Application Ref:	2025/0668			 Ribble Valley Borough Council www.ribblevalley.gov.uk
Date Inspected:	Pre-App	Site Notice:	N/A	
Officer:	Stephen Kilmartin			
DELEGATED ITEM FILE REPORT:				REFUSAL

Development Description:	Proposed full repair and conversion of the existing Field Barn to make a dwelling house within the linked farmhouse cluster at Alder House Farm.
Site Address/Location:	Alder House Holden Lane Bolton by Bowland BB7 4LZ

Field Barn  
Proposed North-West Elevation

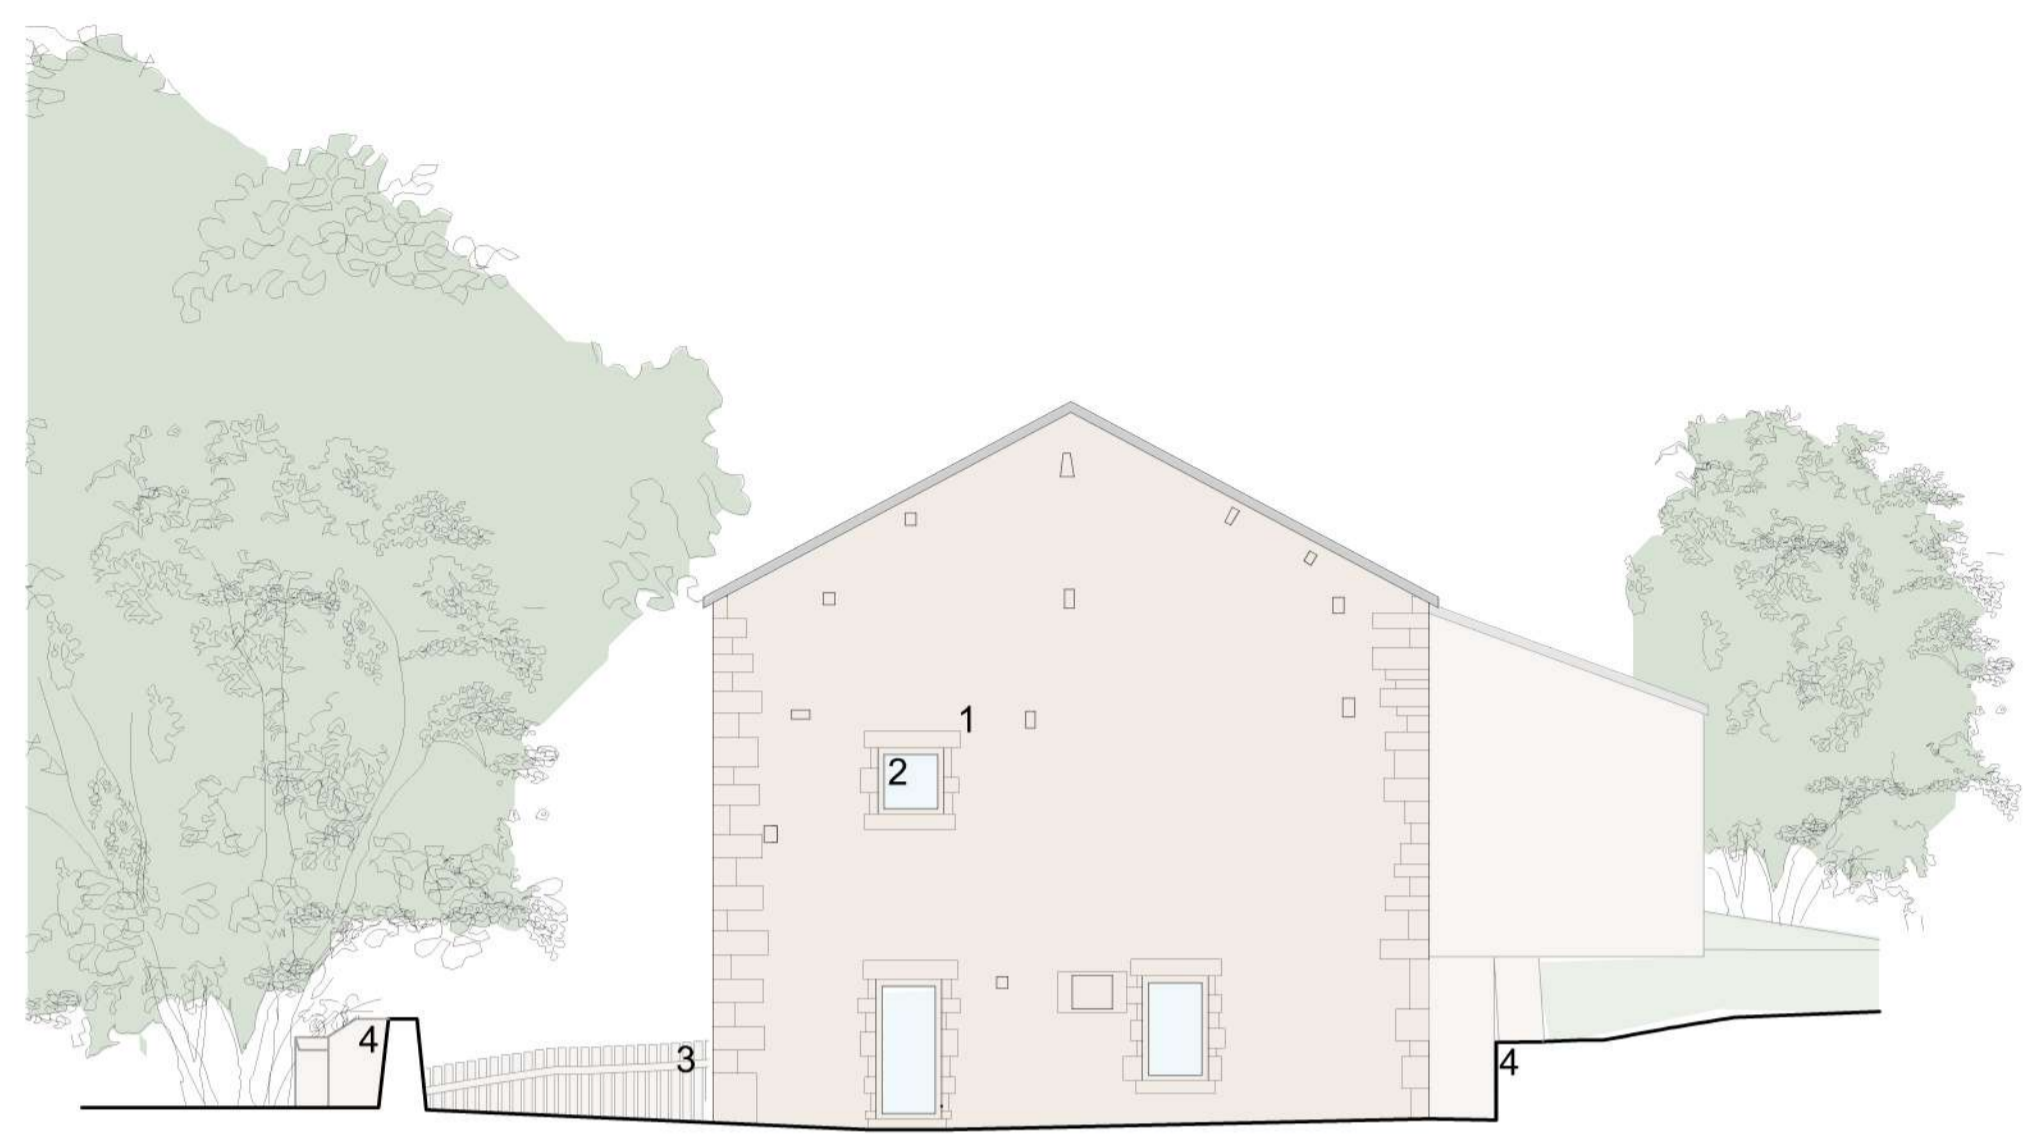
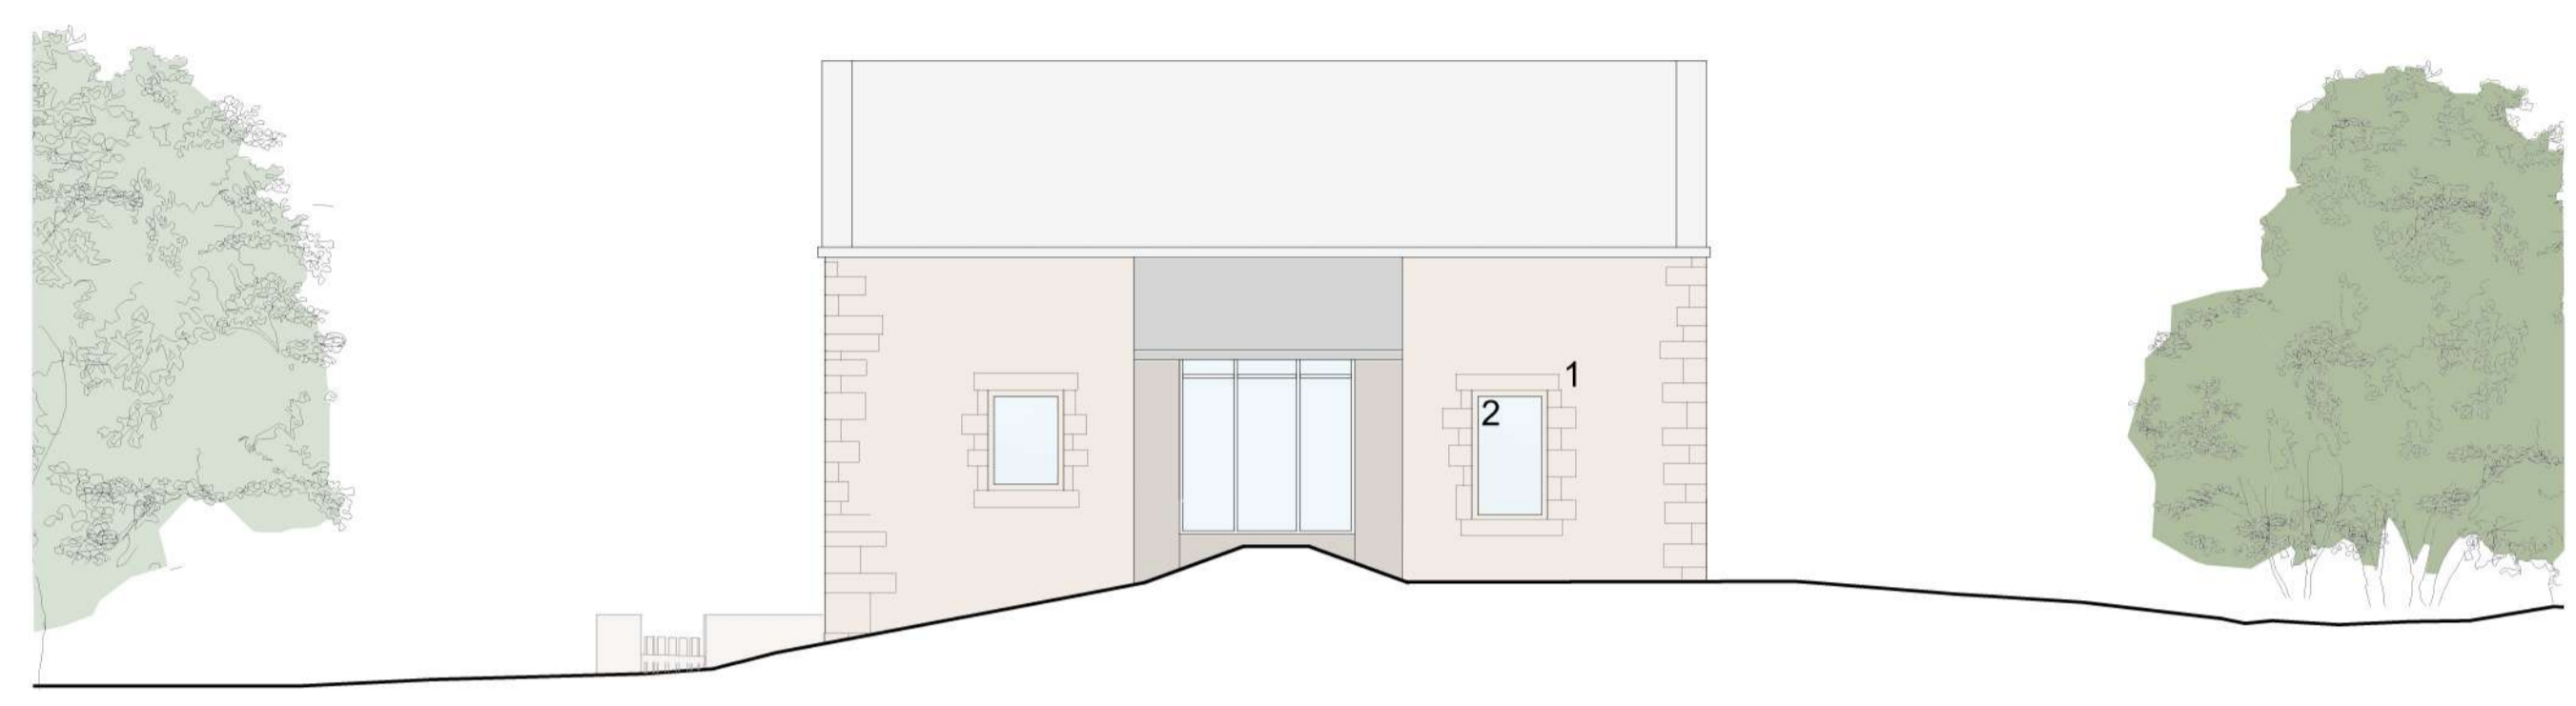
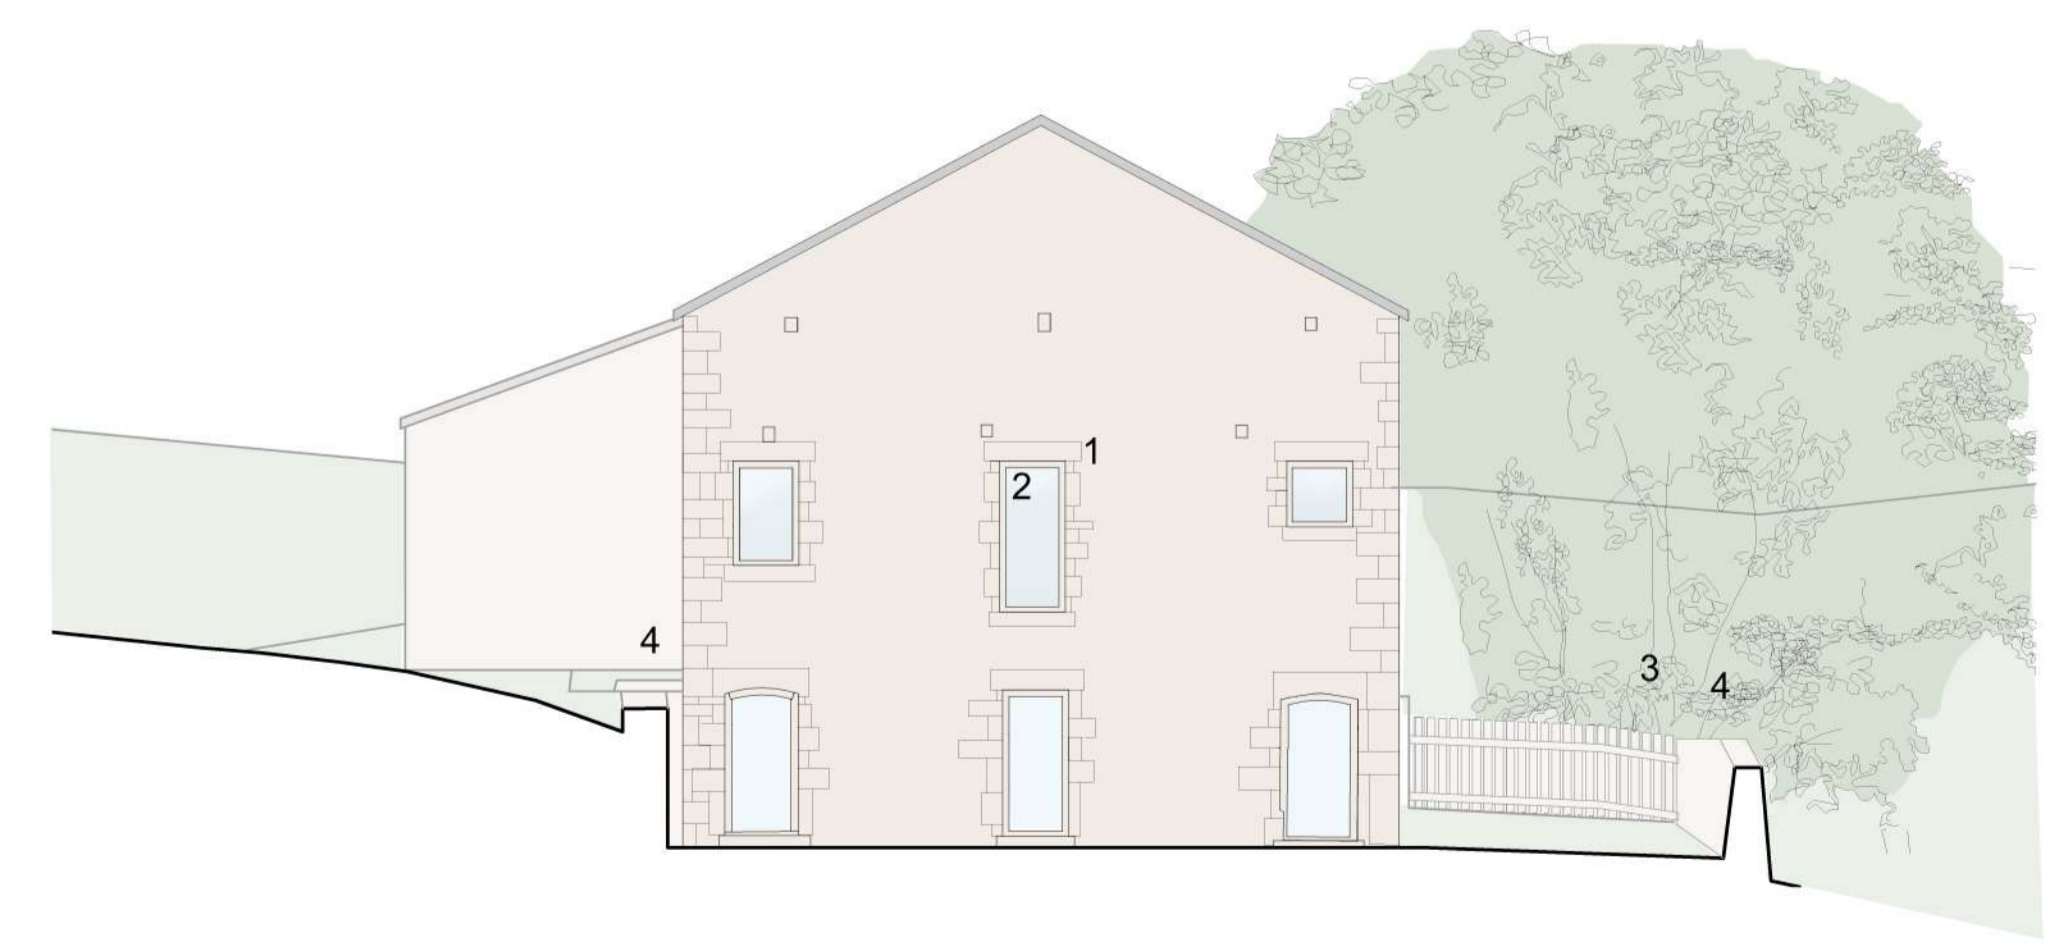
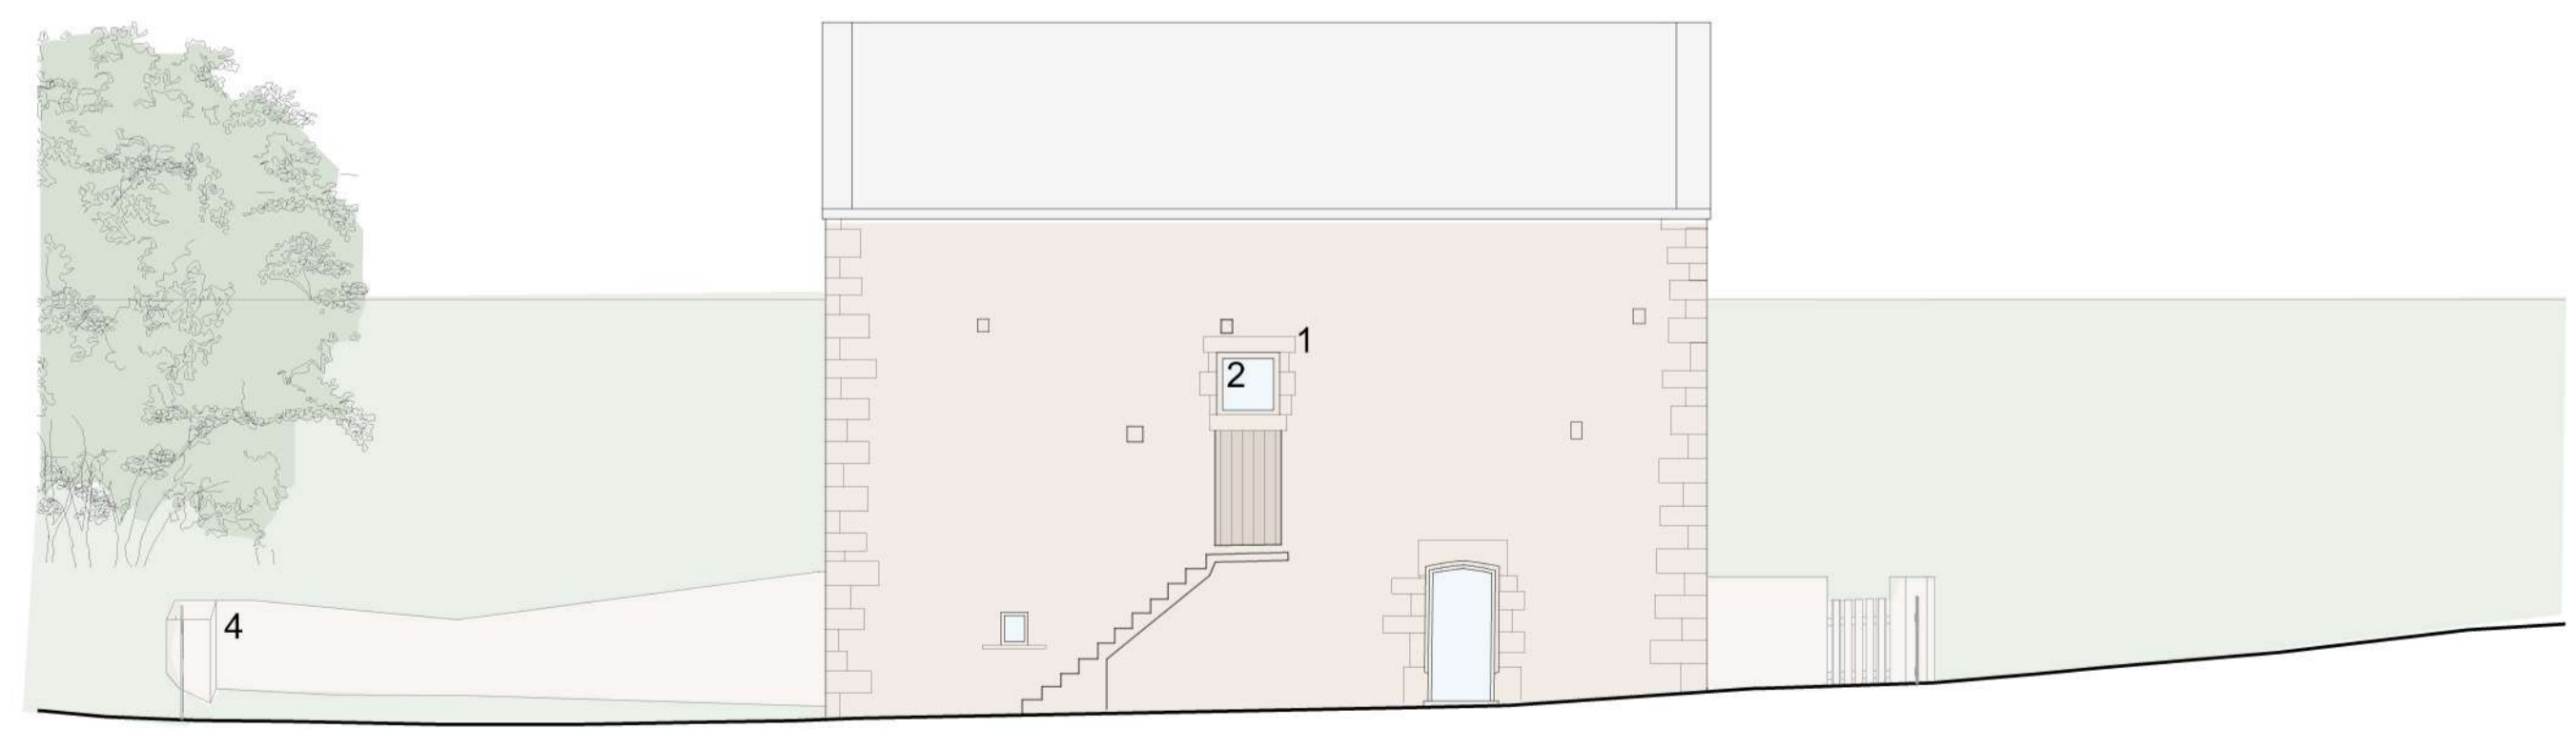
- North-west Elevation:
Introduction of two new window openings and one door opening
- South-west Elevation:
Introduction of two new window openings and creation of recessed infill in 'cart-door' opening to accommodate glazed door with sidelights
- South-east Elevation:
Creation of three windows at first floor and introduction of three timber frame windows into existing openings at ground floor
- North-east Elevation:
Introduction of timber framed window into one opening at ground/lower ground floor, introduction of one feature window above existing doorway opening serving external stair

Whilst the proposed alterations will result in the character of the building becoming clearly residential, the proposed alterations are considered to be minimal in their intervention and as such would not undermine the inherent character of the building to a degree that would be considered significantly harmful.
